Second Response to Observations Received

Borrisbeg Renewable
Energy Development (ABP
Ref. 318704-23)

Project Title: **Borrisbeg Renewable Energy Development (ABP Ref. 318704-23)**

Document Title: **Second Response to Observations Received**

PROJECT TITLE: Borrisbeg Renewable Energy Development		
DRAWING TITLE: Proposed Access Junction B		
PROJECT No.: 220310	DRAWING No.: 220310 - 38	SCALE: As Shown @ A3
DRAWN BY: GO	CHECKED BY: KD	DATE: 11.12.2023
		REVISION: P01

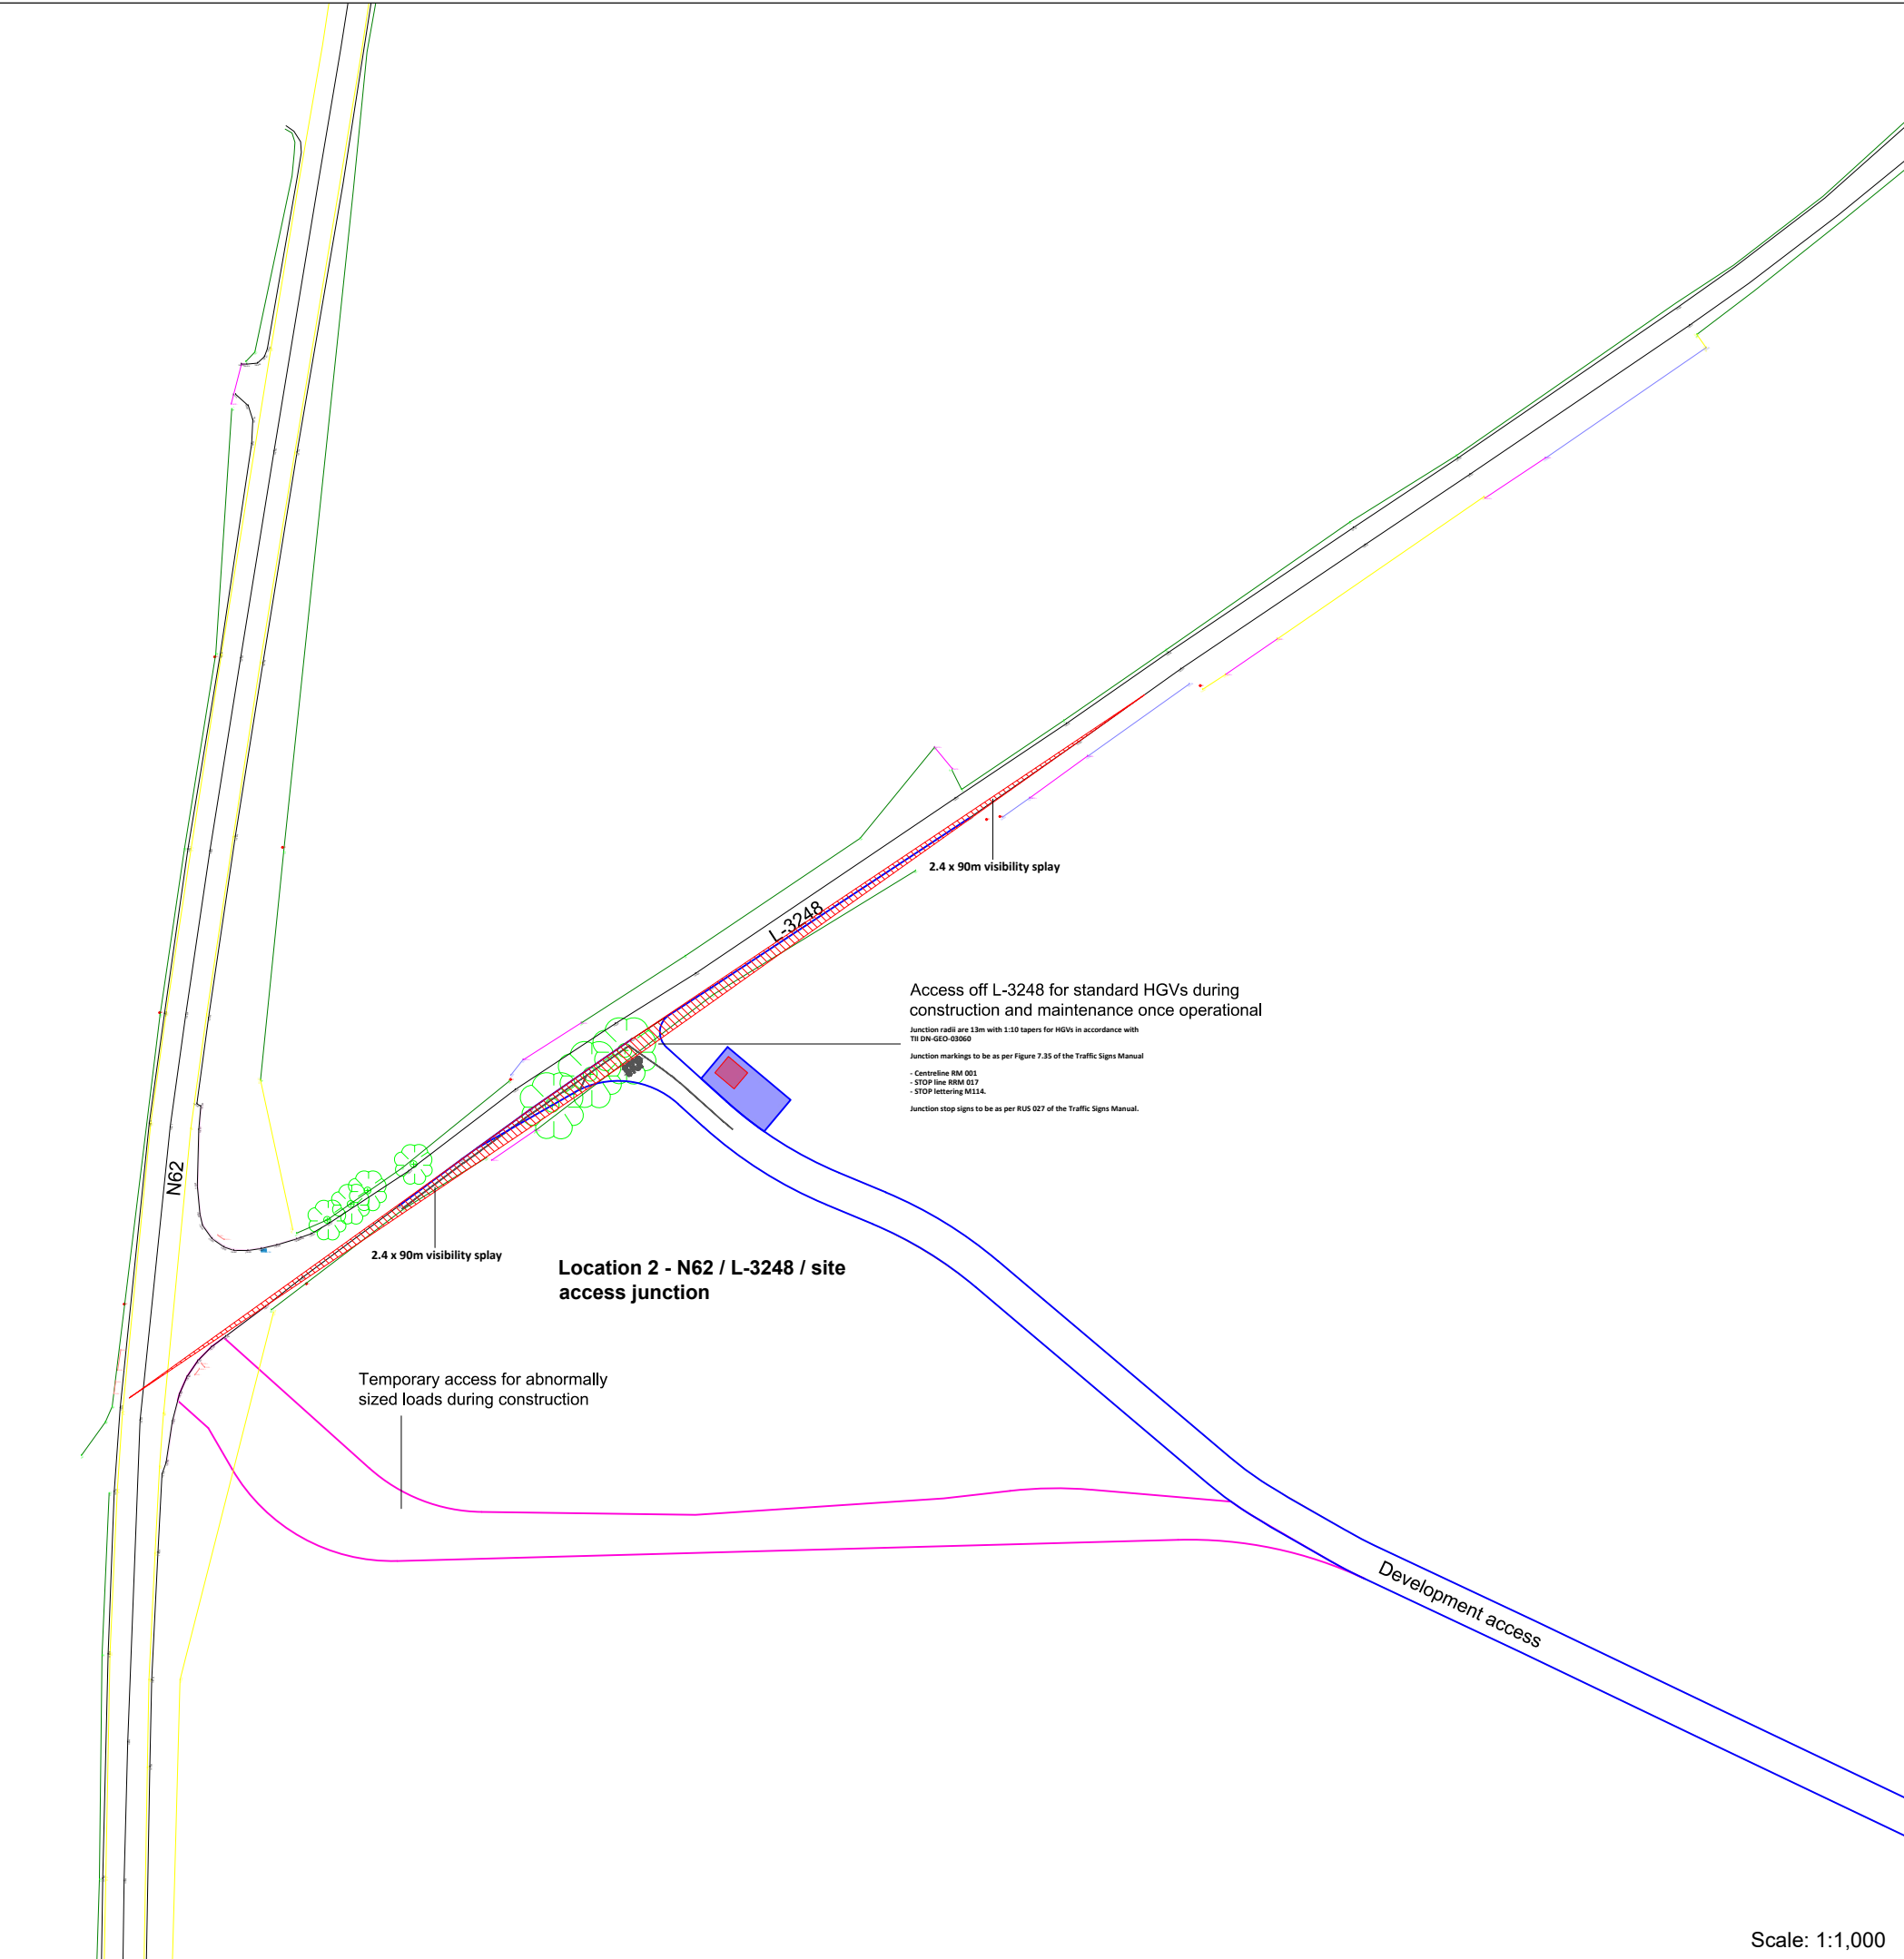
The Third-Party Submission expresses concern regarding road safety at the junction of the proposed site entrance and recommends an alternative access point.

Chapter 3 of the EIAR specifically deals with consideration of alternatives. Section 3.2.5.6.3 '*Alternative Site Access Points*' of the Chapter 3 outlines the rationale as to why the currently proposed L-3248 site access was chosen as the safest option. The proposed site access design is in accordance with TII Official Policy, and its ability to achieve the necessary sightlines for traffic safety.

It is reiterated that the use of the temporary abnormal loads entrance will be temporary in nature and used only at night-time under strict supervision, over a short period of the construction phase. The abnormal loads entrance will be reinstated after all abnormal loads have been delivered to site.
